Application number: 2020/91919	
What is the application for?:	Demolition of existing supermarket and erection of block of 6 flats with associa
Address of the site or building:	The Co Operative Food, 19, Northgate, Almondbury, Huddersfield, HD5 8RX
Postcode:	M60 0AG

PROPOSED ELEVATIONS C & D

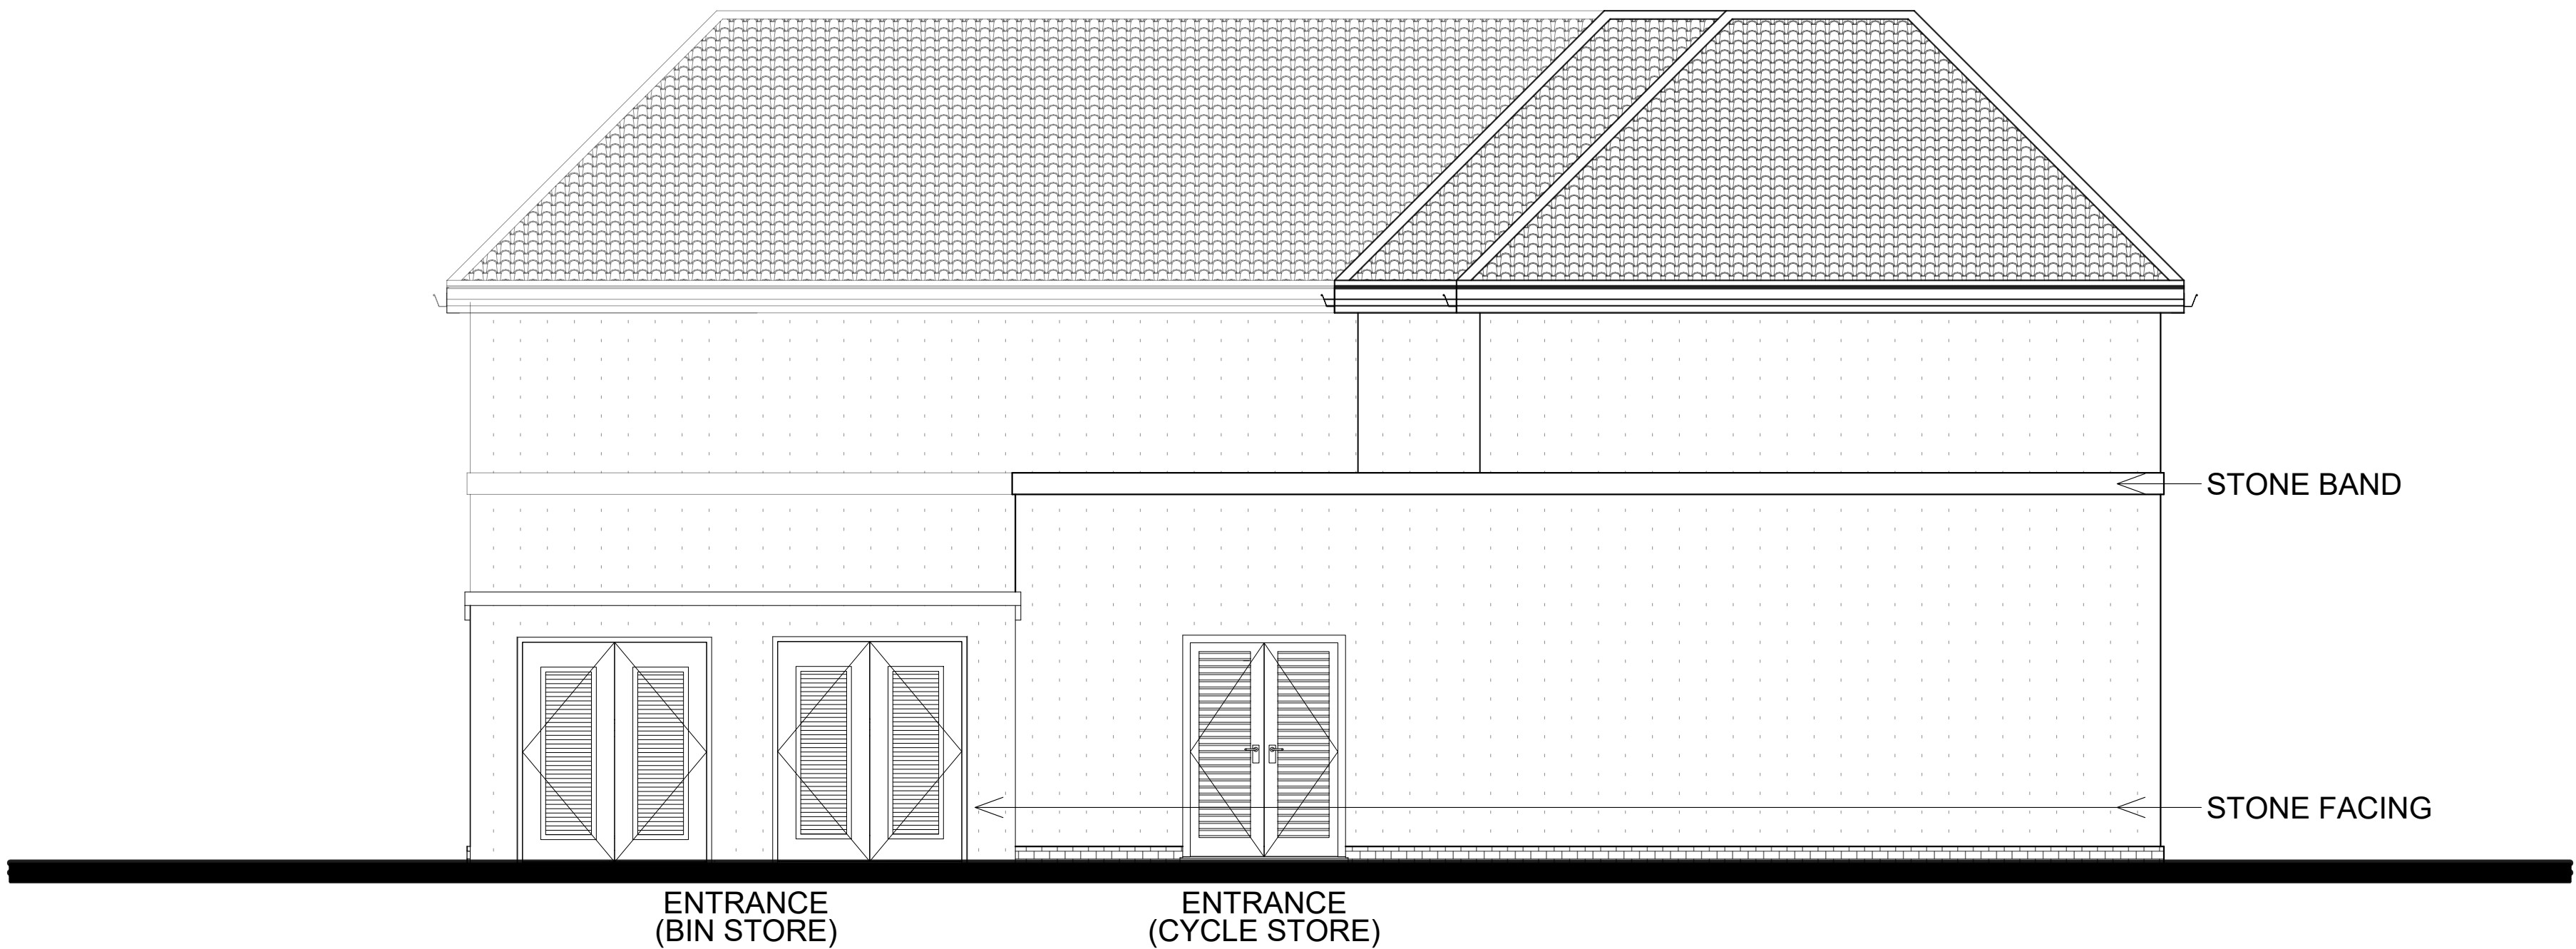
Type of comment: An objection
<p>Whilst there is no doubt that the existing supermarket building is a negative element within the townscape of this important and historic Conservation Area, the proposal to replace it with a block of 6 flats can only be classed as mediocre.</p> <p>It is accepted that the site layout constrains redevelopment proposals but equally the scheme pays little attention to the architectural and historic form of the Northgate area. In order to provide adequate parking for the number of flats proposed, the whole frontage is to be laid out as a hard-standing area. This appears contrary to the values that should be achieved within Conservation Areas in general.</p> <p>There is, in addition, meagre detailing with regards stonework and related materials and it is considered that any development should be in coursed York stone to all elevations, not simply on the front elevation.</p> <p>In summary, although it could be argued that the proposal is better than what currently exists, the result is disappointing and could be rectified by reducing the number of units with layout and elevational amendments that include reduced parking requirements.</p>
